DECISION DELEGATED TO HEAD OF PLANNING

Application No: H01-0814-22 **Applicant:** Mr J Parnell

Proposal: Proposed single storey rear extension, two storey front and rear extensions, detached garage and alterations to site access - approved under H01-0086-22. Amendments to garage location, roof, rooflights and window.

Location: 52 Backgate Cowbit Spalding

DRAWING
Proposed Garage Plans

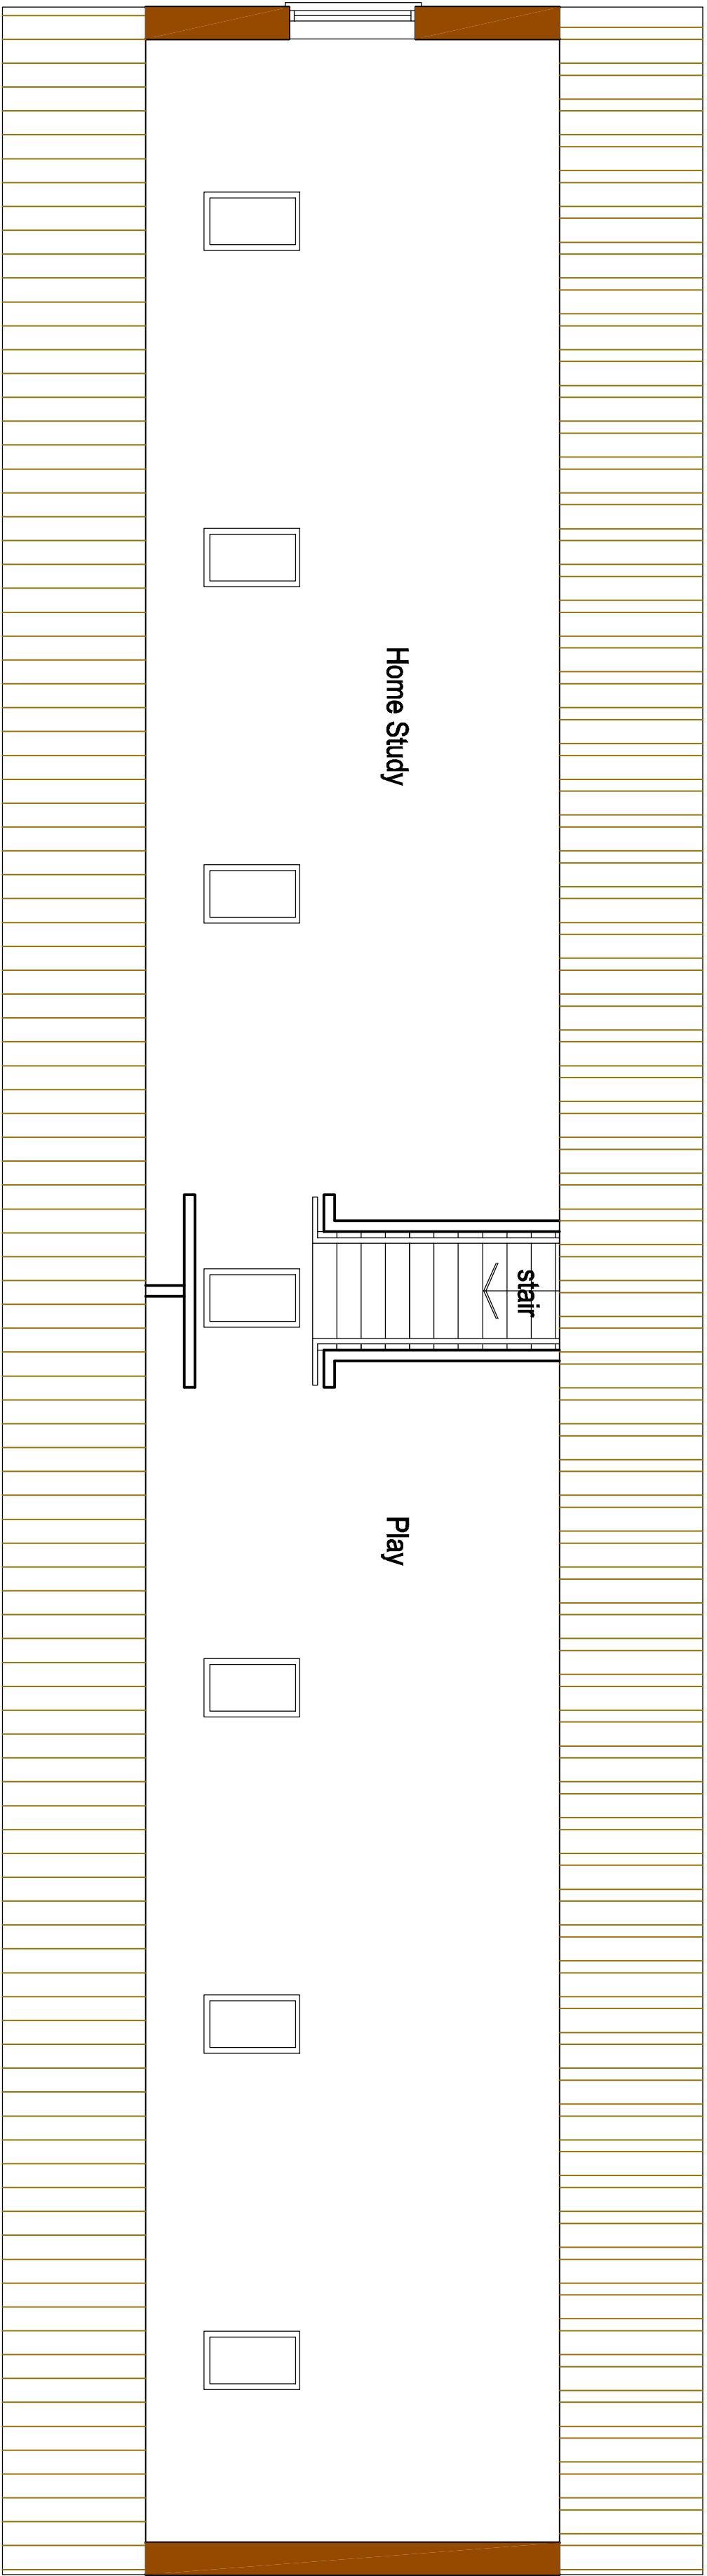
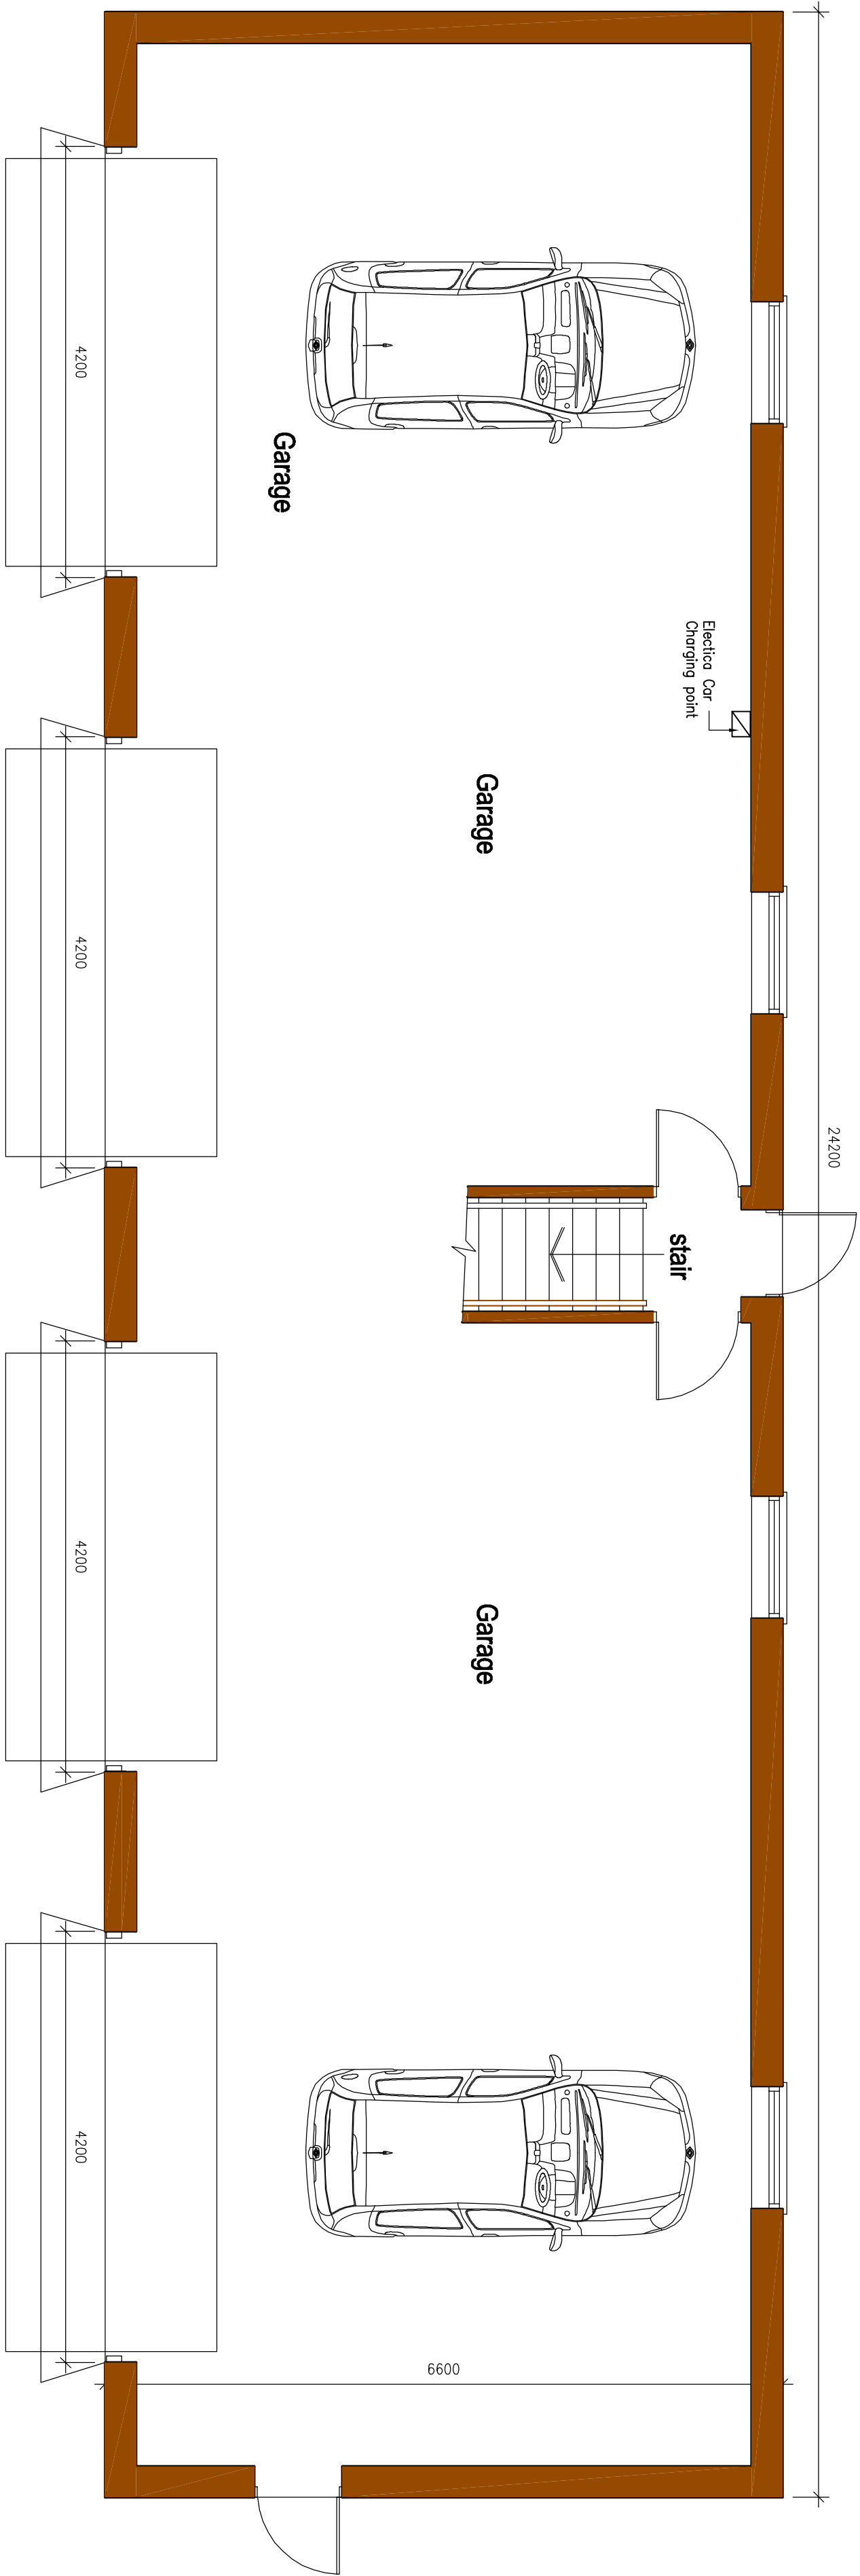
The garage will now be located 1.2 metres from the boundary rather than 0.615 metres. The width and length of the garage will remain at 24.2 metres in width. The gap between the dwelling and garage will remain at 12 metres. The five rooflights on the southern elevation roof slope will be removed and seven rooflights installed in the northern roof slope. A new window is to be sited in the eastern elevation wall at first floor level. The garage height will remain at 6 metres as approved under the application H01-0086-22 but will change from a hipped roof to a gable roof. Materials of construction are to remain as originally approved.

5. The approved footprint / siting of the garage will not be moved materially and will not have a material impact on a neighbour.
6. The height of the garage will remain at 6 metres.
7. The amendment will not result in any potential overlooking of any neighbouring property as the relocated rooflights face garden space and an agricultural use building.
8. The garage remains quadruple bay and has the same height, width, length and materials of construction as previously approved.
9. The proposal does not amount to new works or elements not considered by any Environmental Statement submitted with the application.
